Our Case Number: ABP-317660-23

Re: Busconnects Kimmage to city centre core bus corridor scheme
Kimmage, Dublin

Observation on a Strategic Infrastructure Development Application

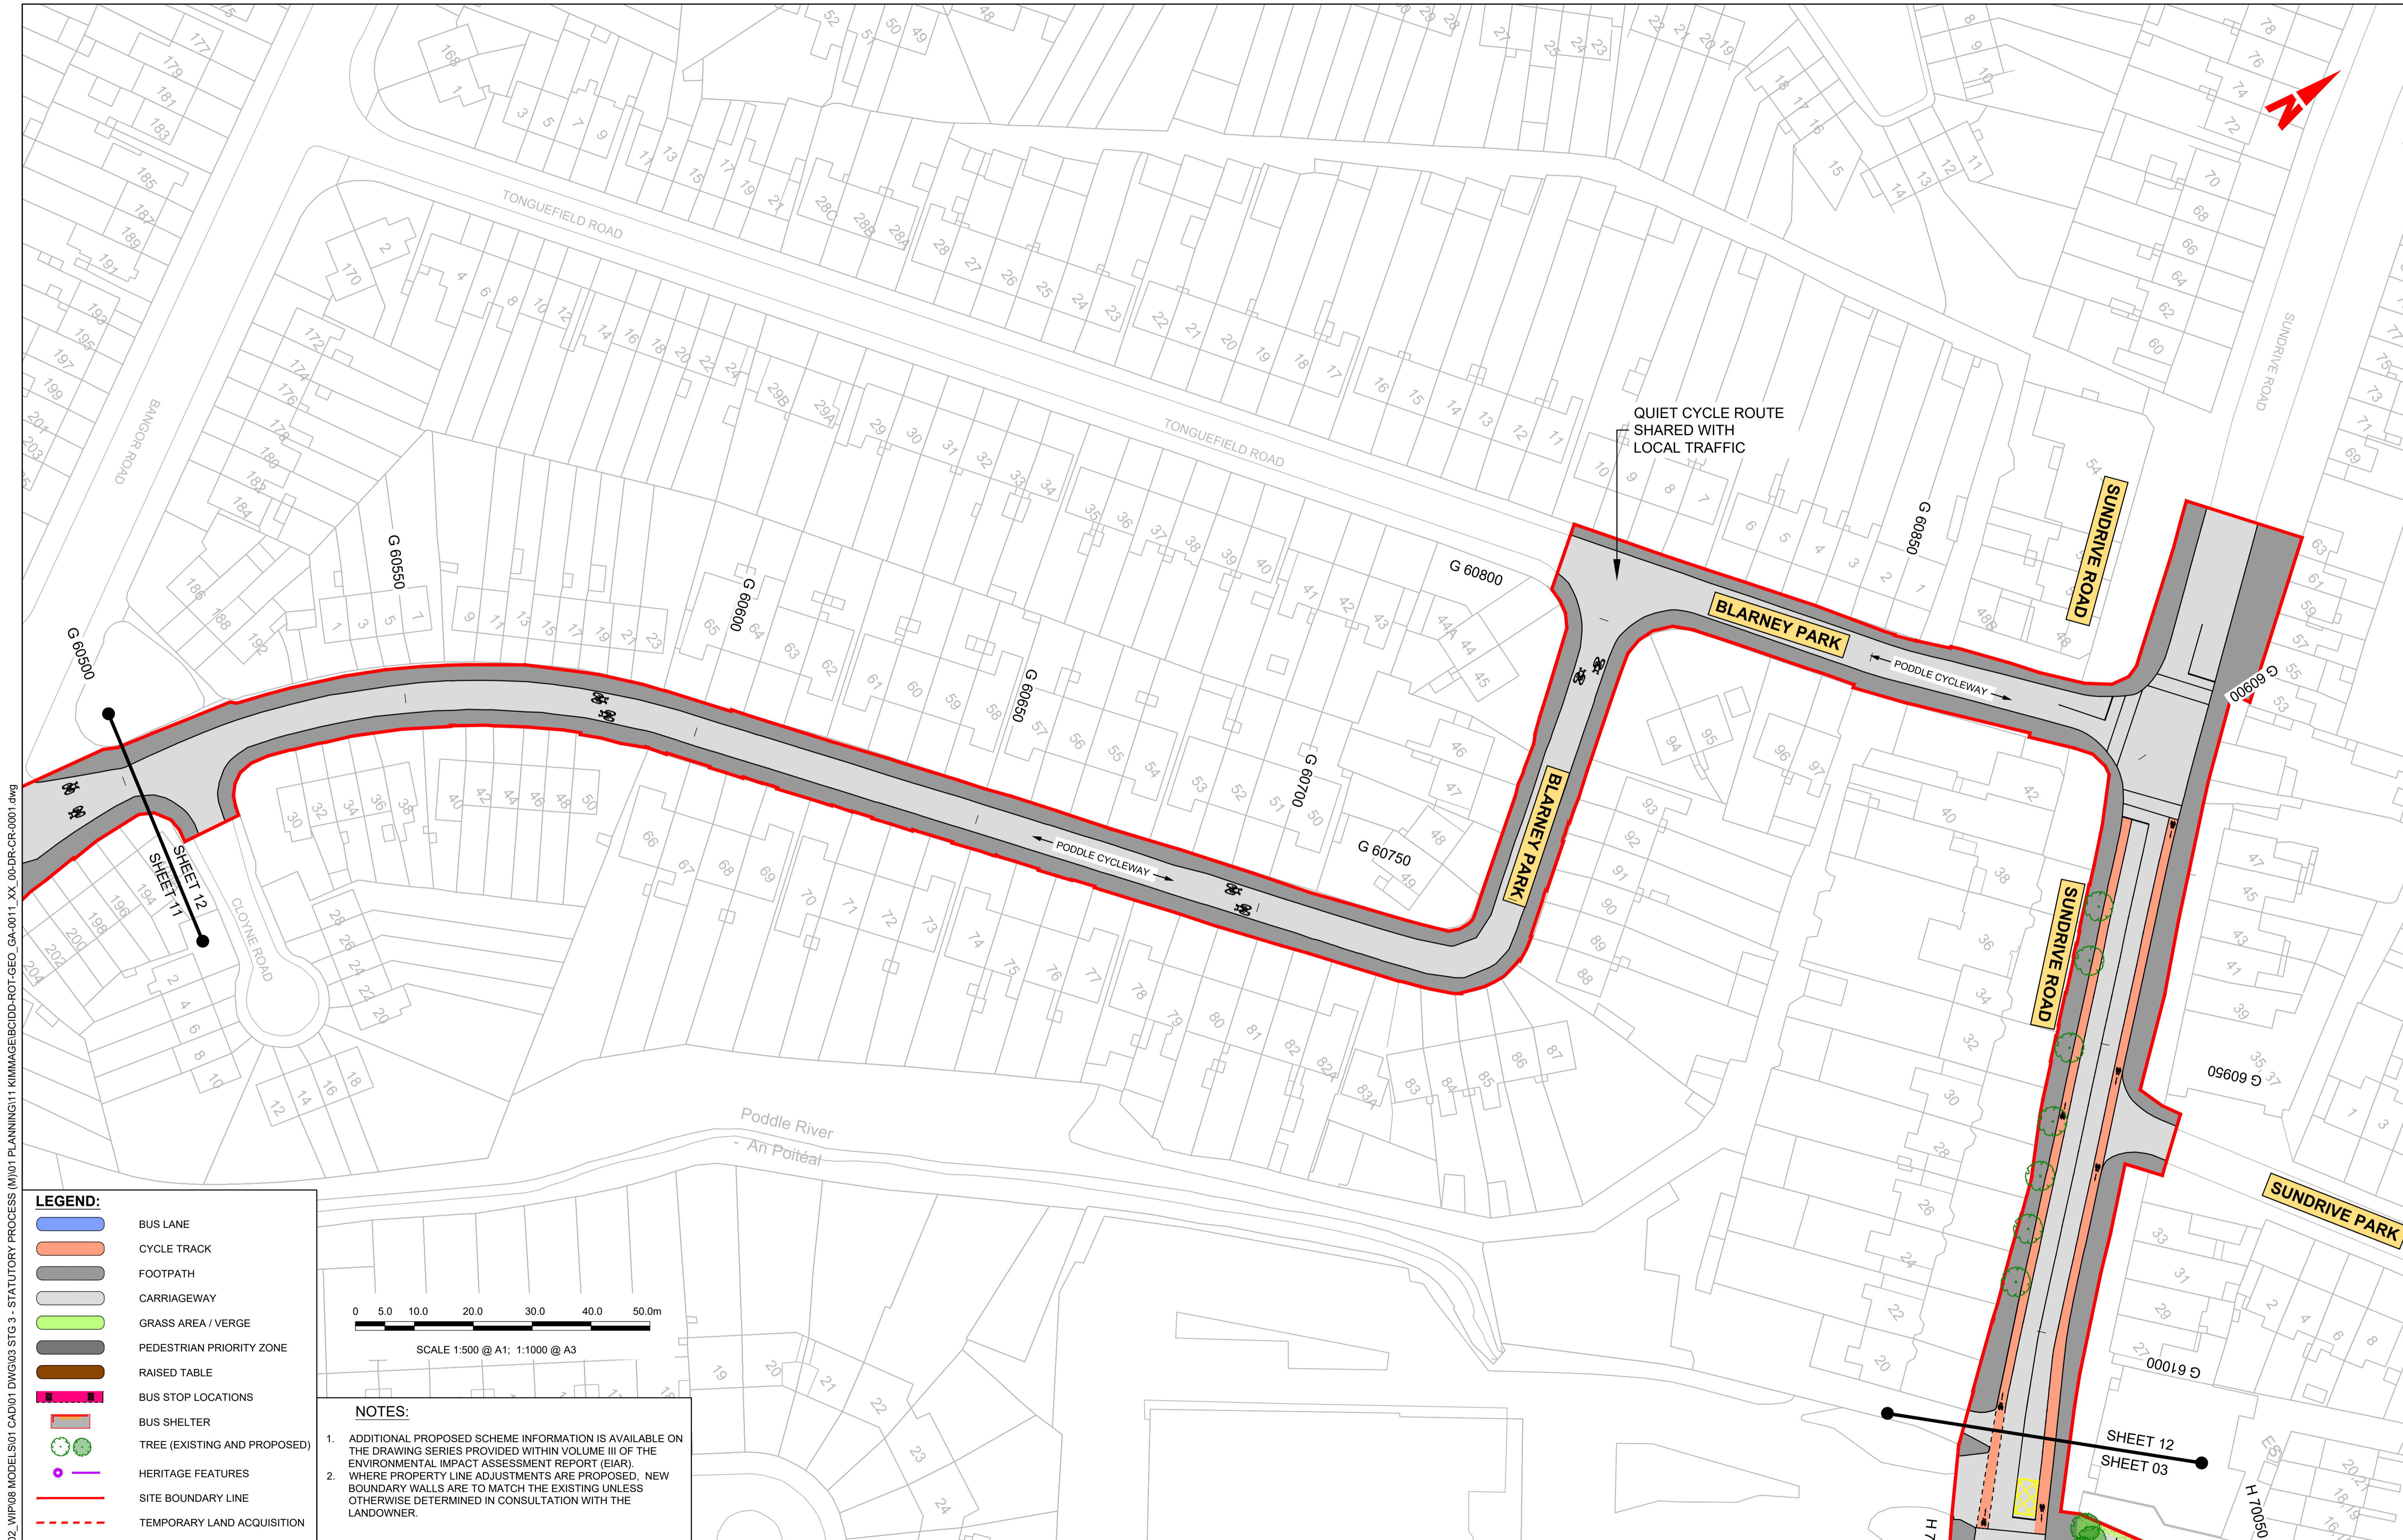
We are a family who live at 44 Clanbrassil Street Upper. The bus stop No **1290 is placed at** the front of our door entrance at 2.7 meters.

On the 3rd public consultation the map shows that the bus stop is being located just beside our house again.

We would like this bus stop to be moved at the location of the Bus Connect initial application of 2019 where the bus stop will be more suitable as there is more space for people to stand up and is not straight in the front door of any property.

-The bus stop is right in front of our property entrance door, anyone waiting at the bus stop can see directly into our property when open the door entrance.

We would really appreciate that this bus stop could be moved to the 2019 proposed location where it is a more suitable location and not in front of any door entrance. (picture and map attached)
